EL PASO COUNTY STORMWATER MANAGEMENT PLAN CHECKLIST

EPC Project Number:

Revised: October 2021

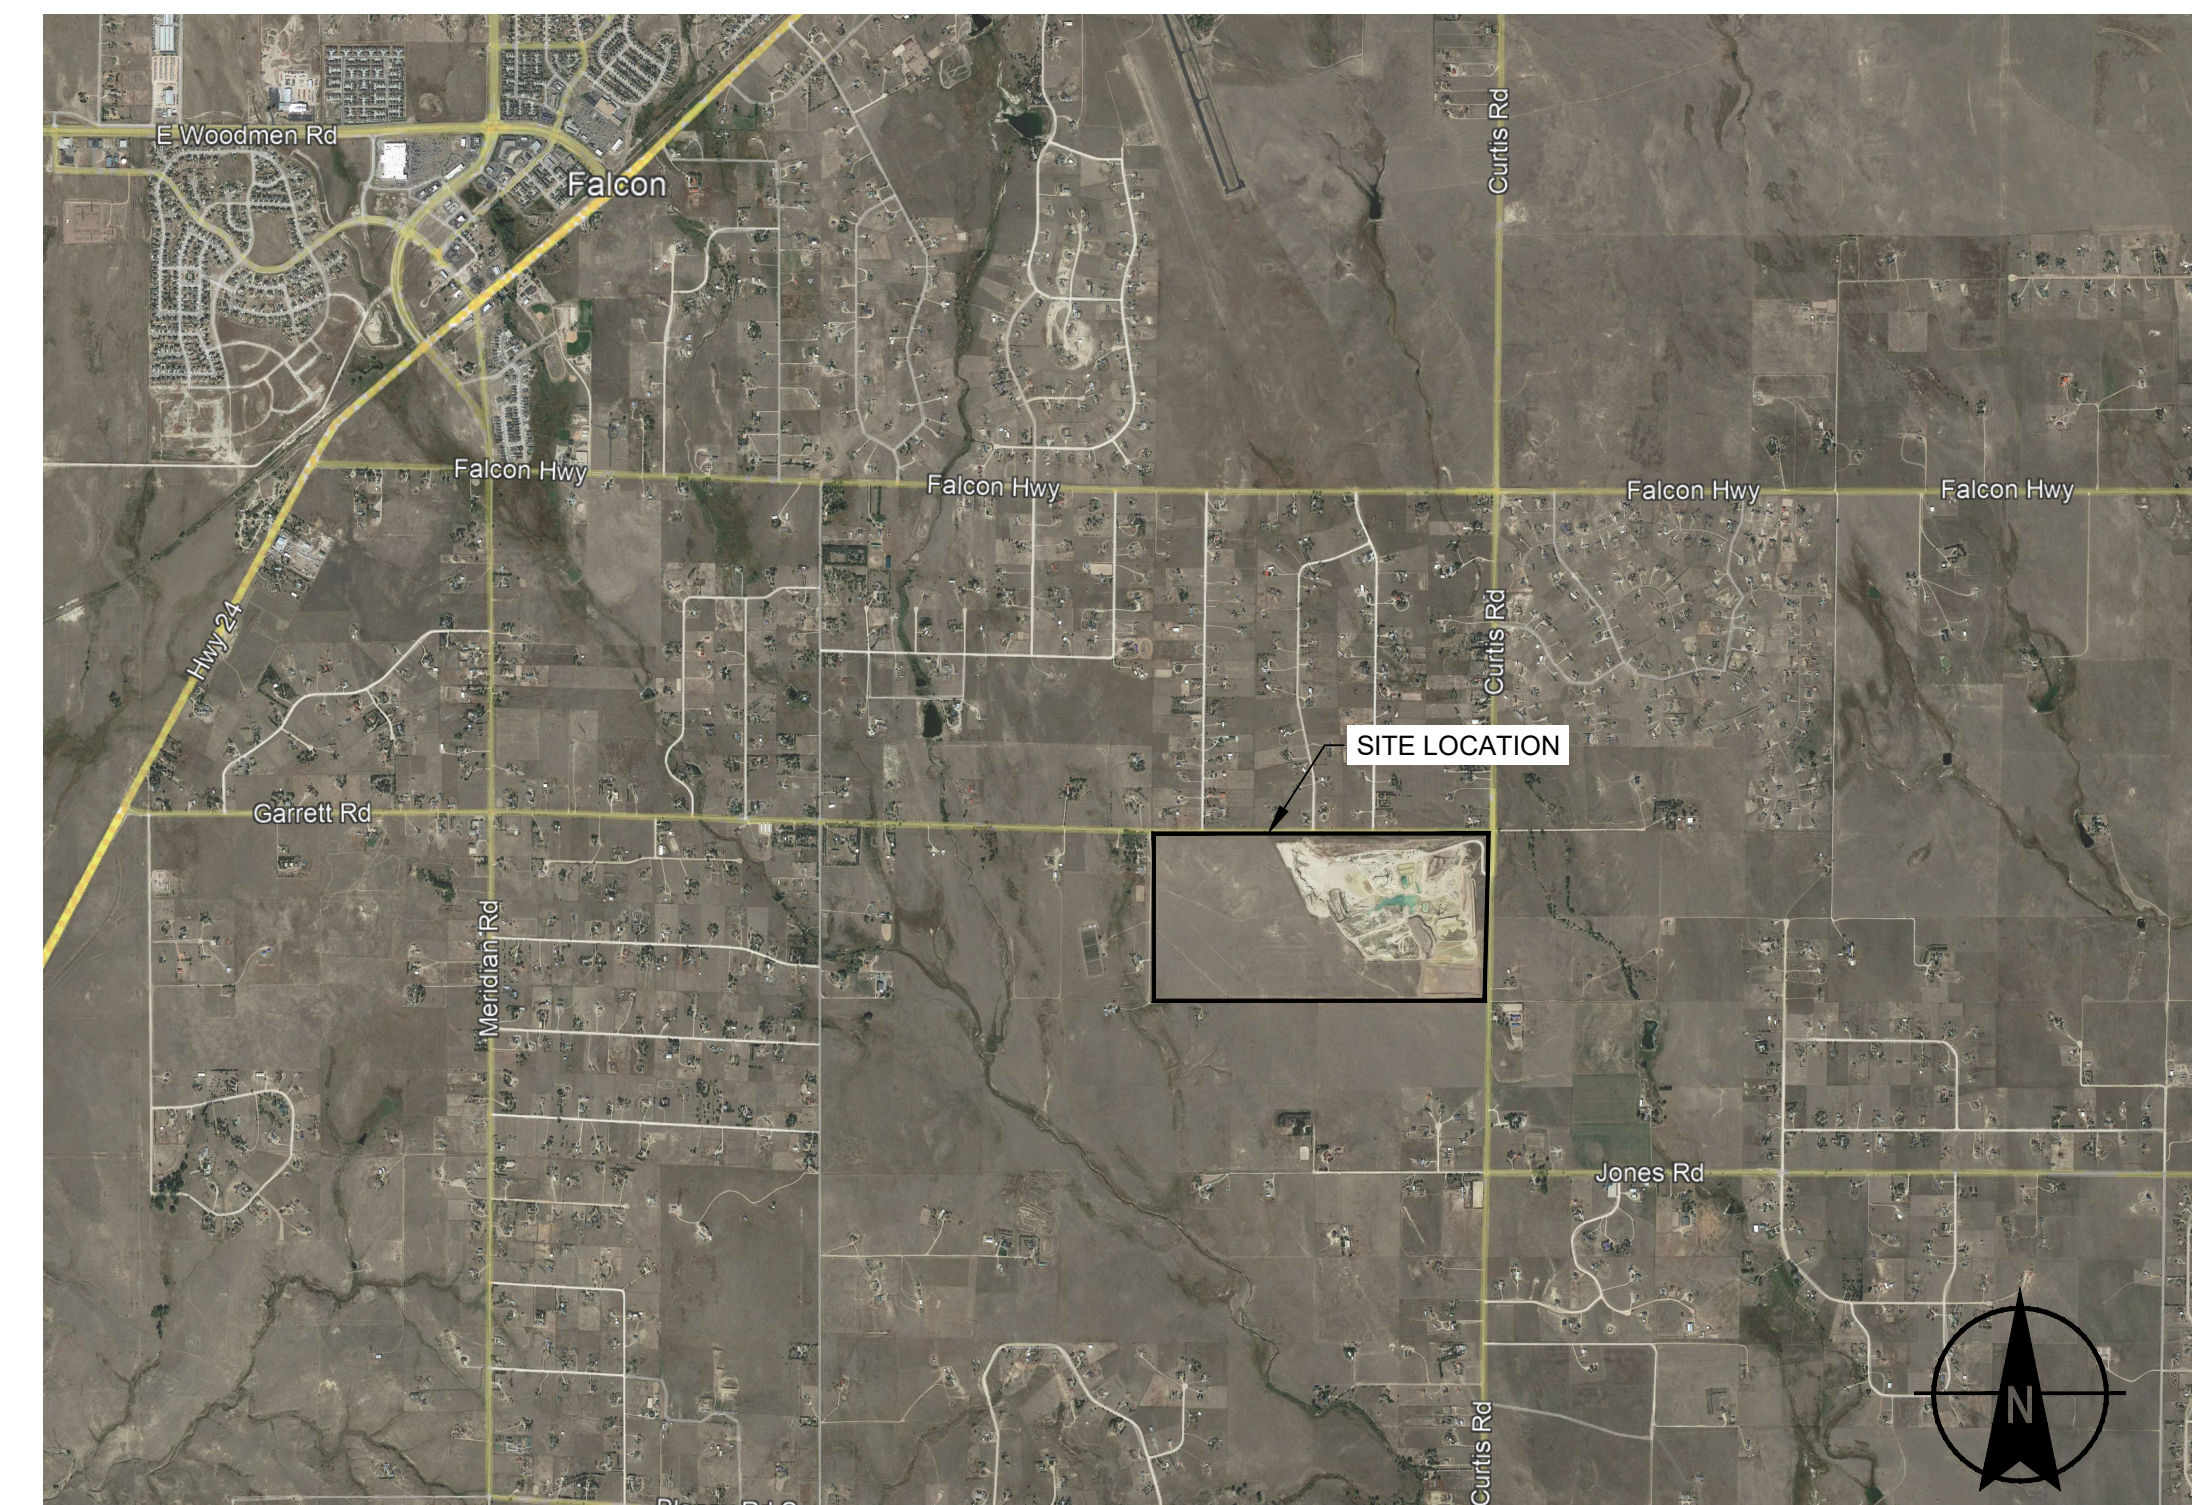
20	Technical drawing details for all control measure installation and maintenance; custom or other jurisdiction's details used must meet or exceed EPC standards		X
21	Procedure describing how the SWMP is to be revised		✓
22	Description of Final Stabilization and Long-term Stormwater Quality (describe nonstructural and structural measures to control SW pollutants after construction operations have been completed, including detention, water quality control measure etc.)		X
23	Specification that final vegetative cover density is to be 70% of pre-disturbed levels		X
24	Outline of permit holder inspection procedures to install, maintain, and effectively operate control measures to manage erosion and sediment		✓
25	Record keeping procedures identified to include signature on inspection logs and location of SWMP records on-site		✓
26	If this project relies on control measures owned or operated by another entity, a documented agreement must be included in the SWMP that identifies location, installation and design specifications, and maintenance requirements and responsibility of the control measure(s)		X

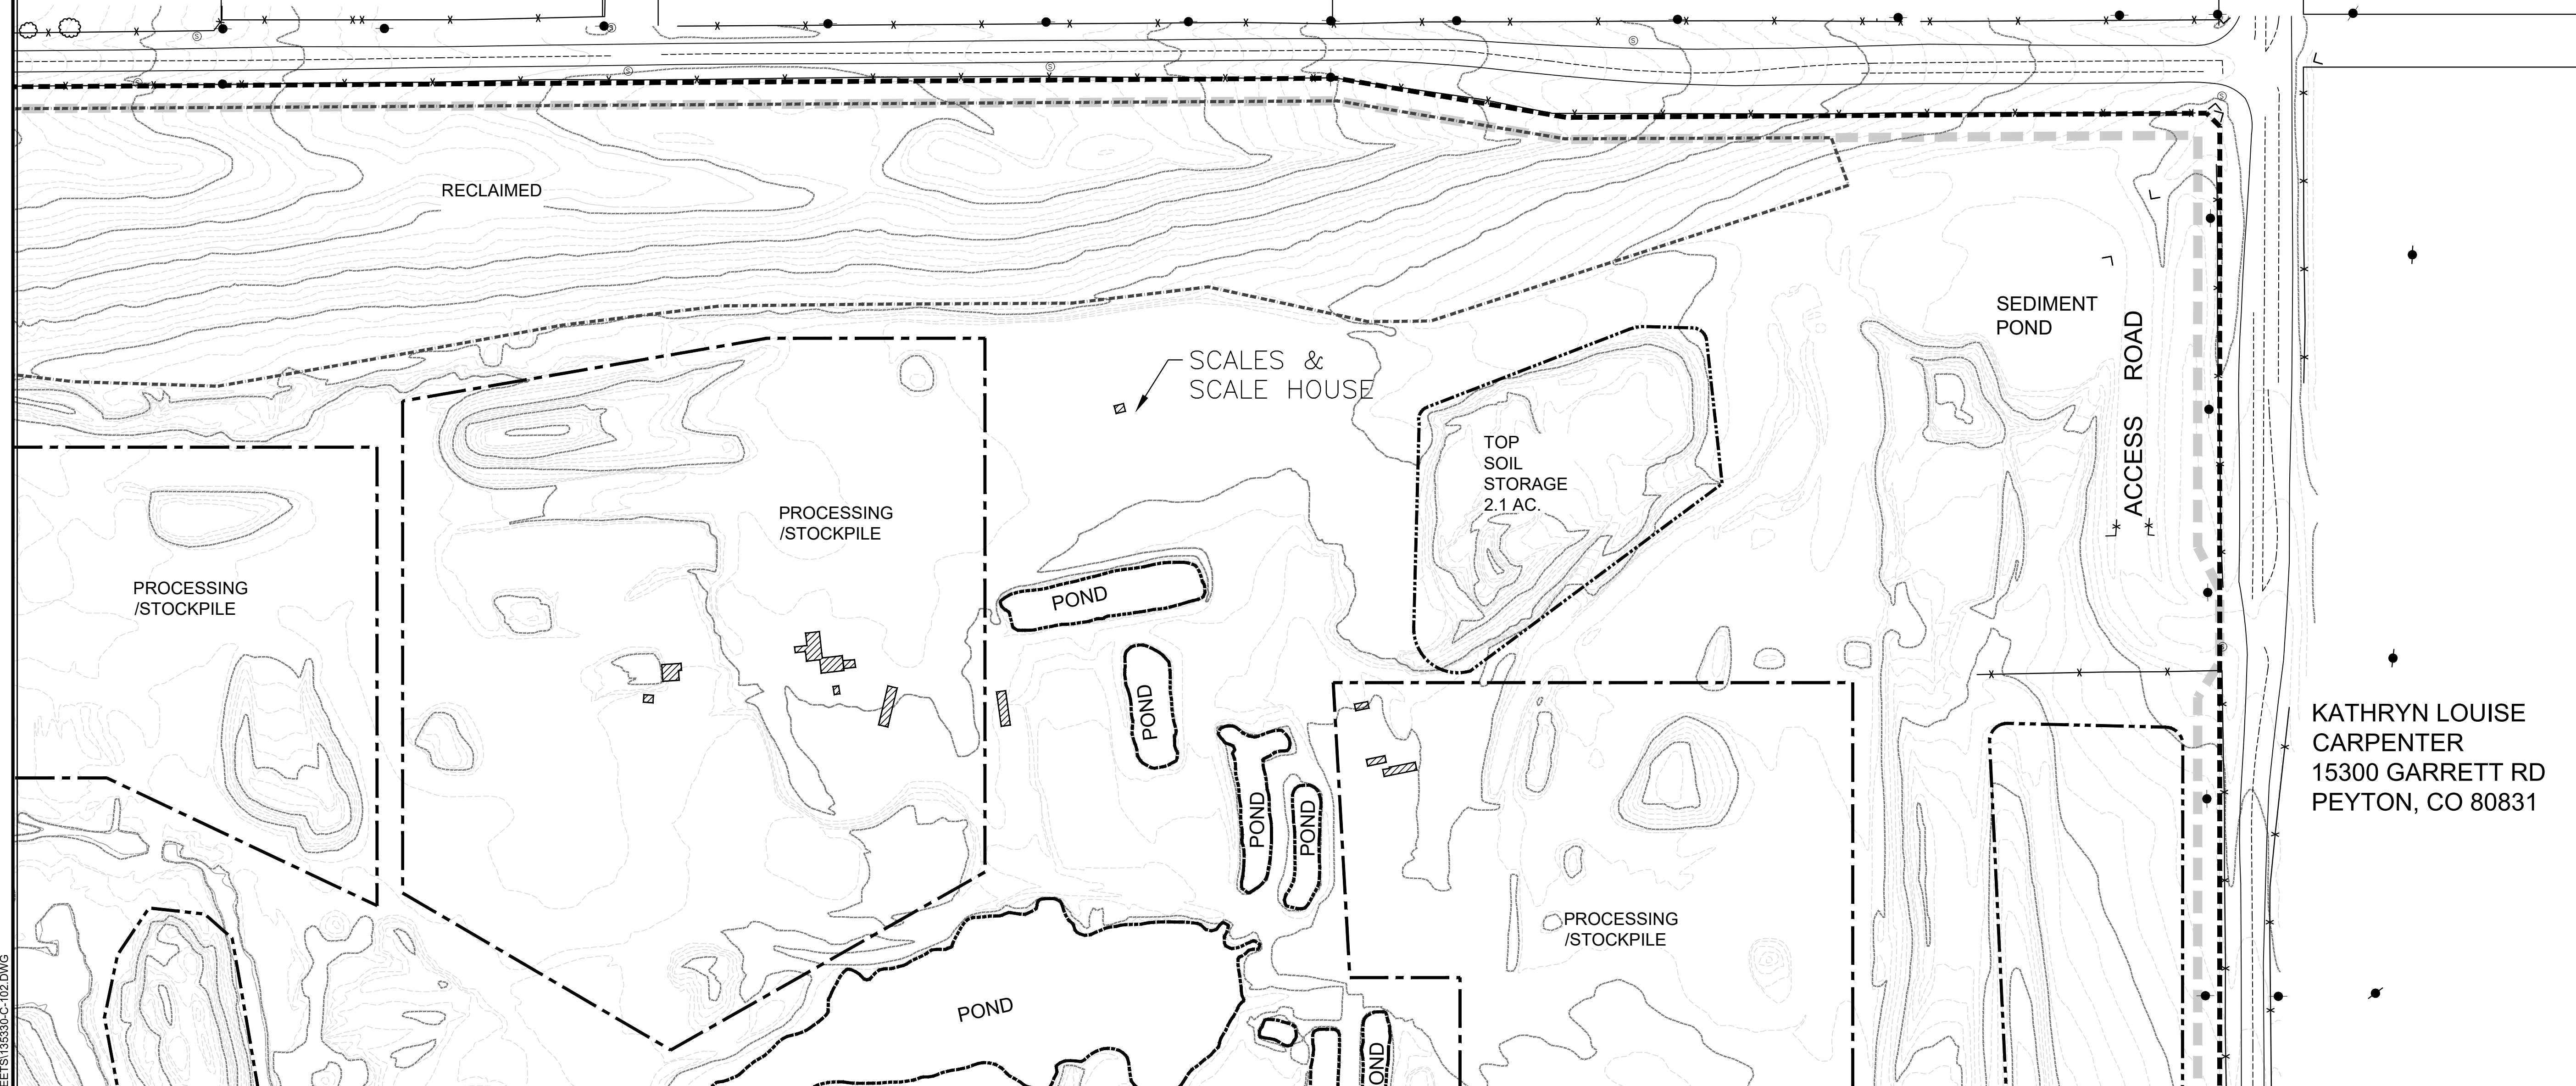
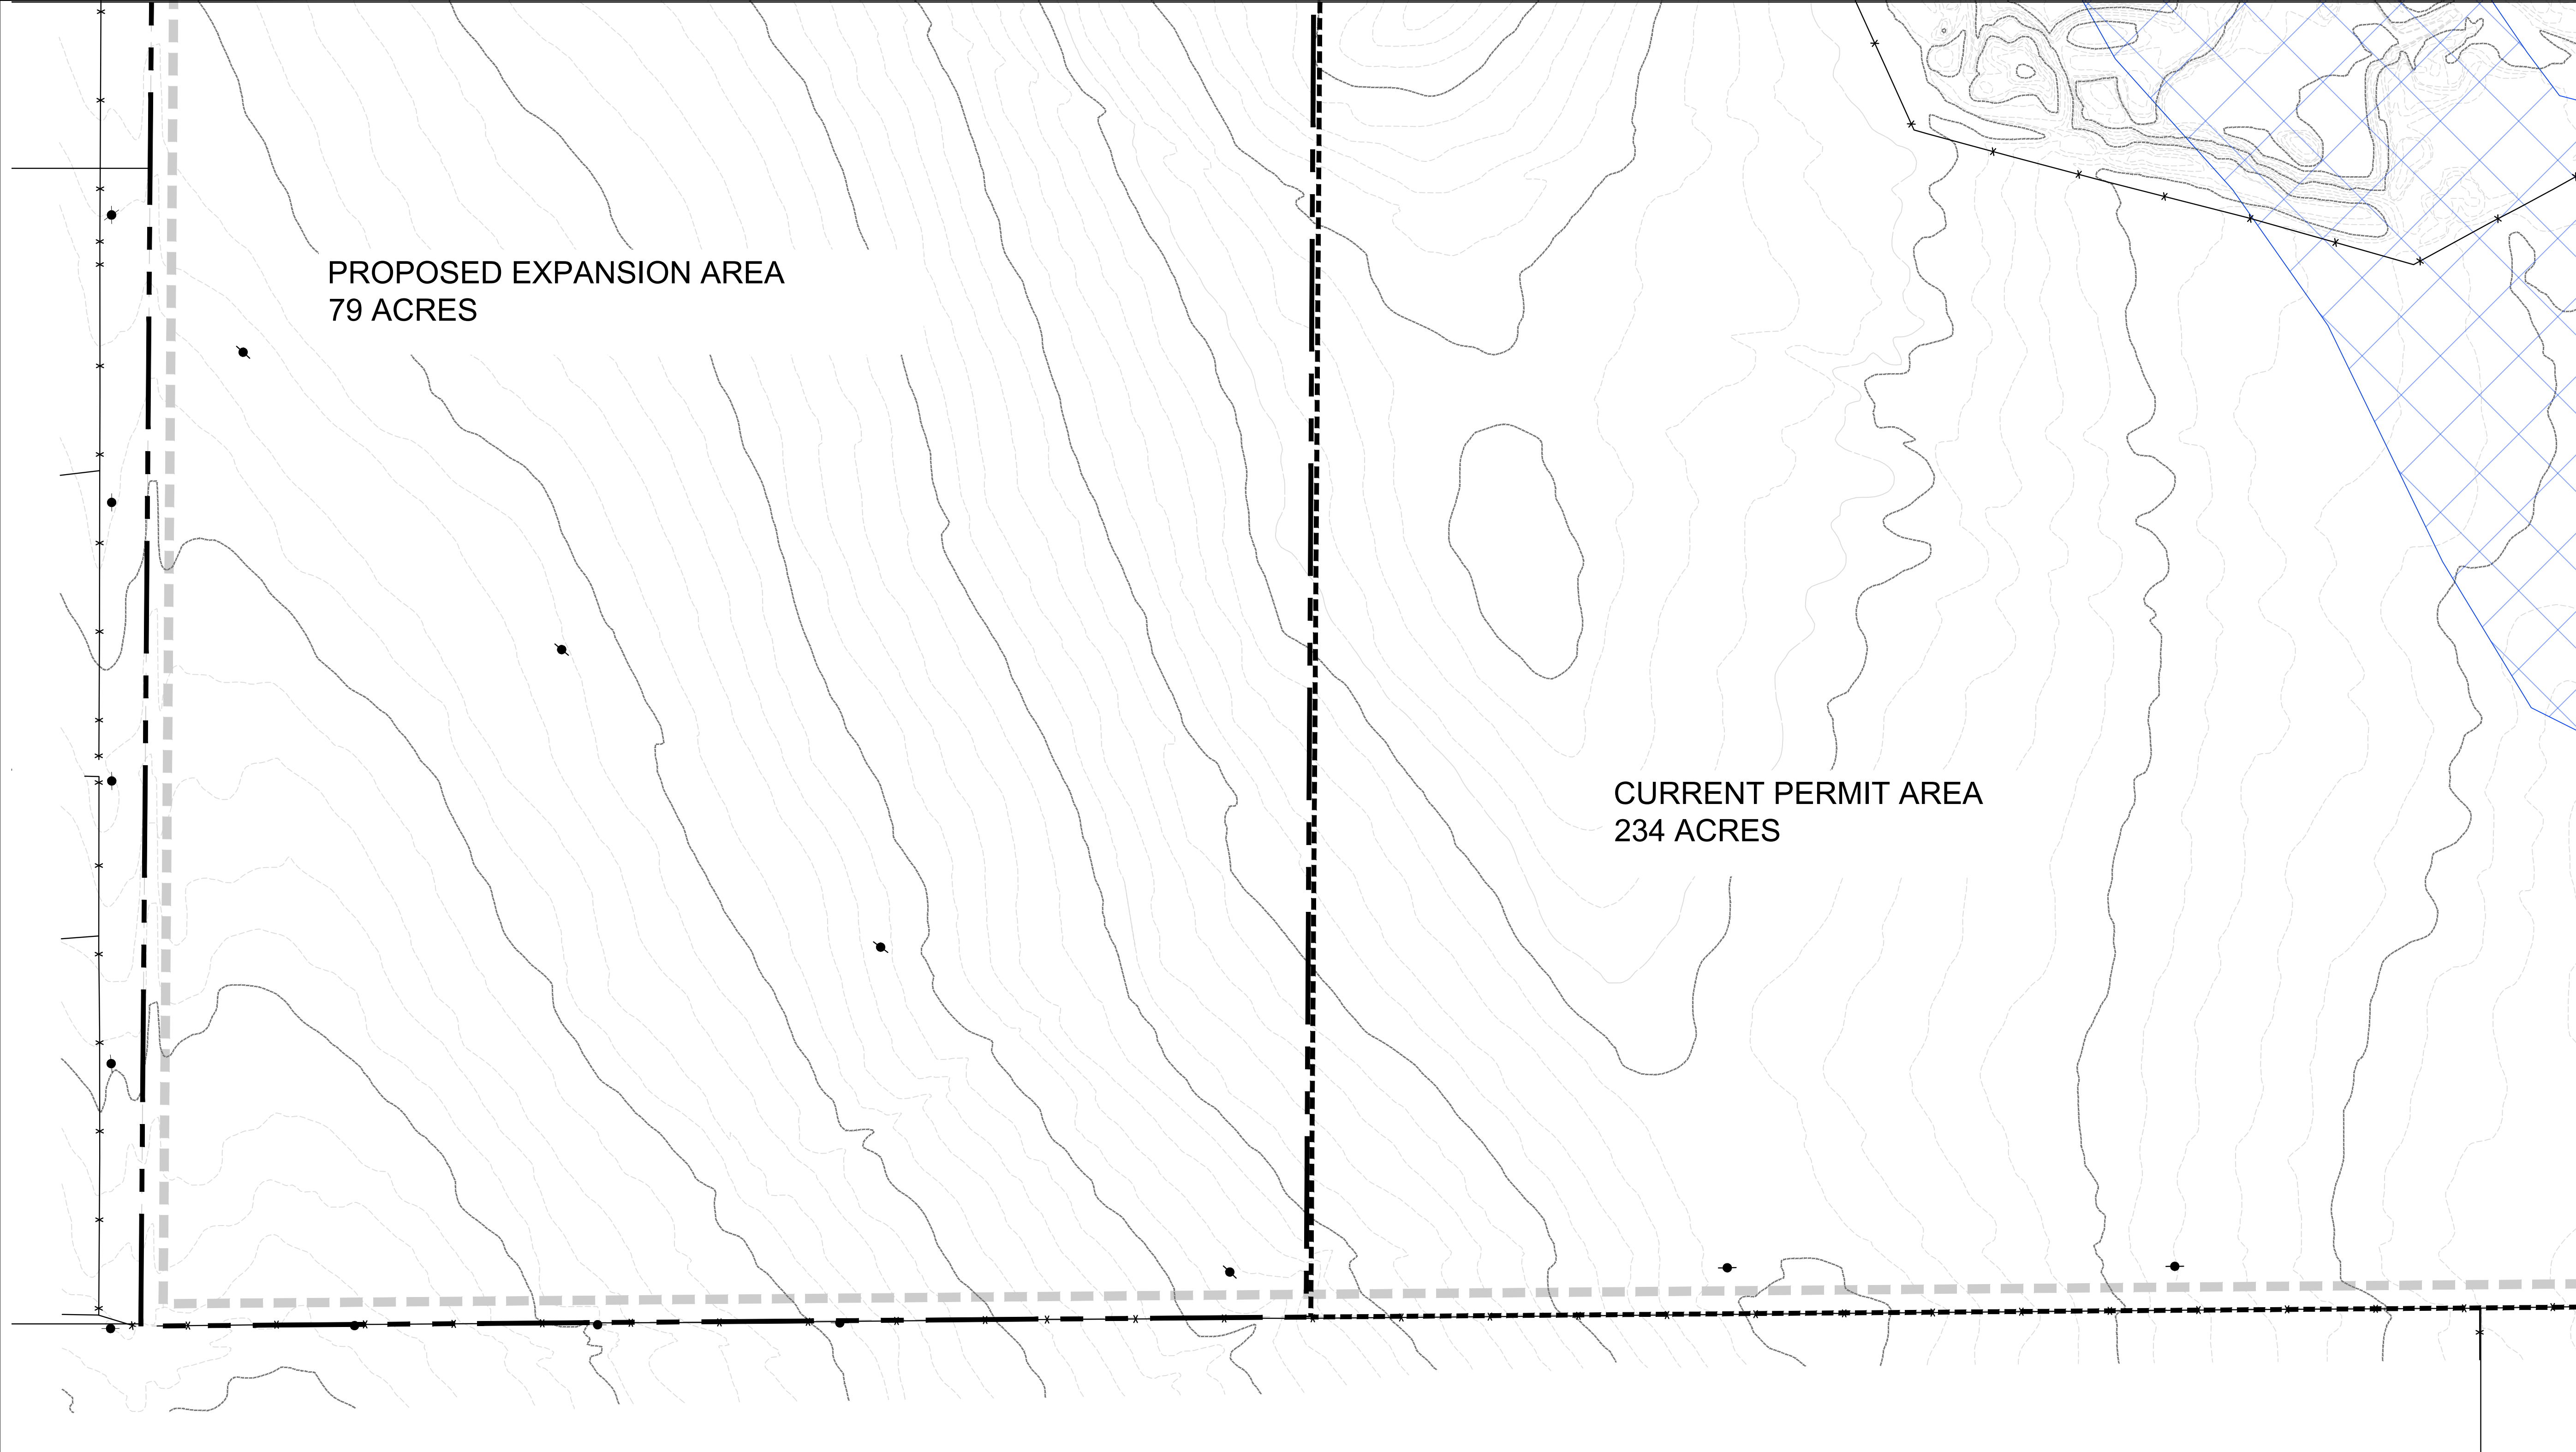
Applicant	EPC
17	SWMP Map to include:		
17a	construction site boundaries		X
17b	flow arrows to depict stormwater flow directions		X
17c	all areas of disturbance		X
17d	areas of cut and fill		X
17e	areas used for storage of building materials, soils (stockpiles) or wastes		✓
17f	location of any dedicated asphalt / concrete batch plants		✓
17g	location of all structural control measures		X
17h	location of all non-structural control measures		X
17i	springs, streams, wetlands and other surface waters, including areas that require maintenance of pre-existing vegetation within 50 feet of a receiving water		✓
18	Narrative description of all structural control measures to be used. Modifications to EPC standard control measures must meet or exceed County-approved details		✓
19	Description of all non-structural control measures to be used including seeding, mulching, protection of existing vegetation, site watering, sod placement, etc.		✓
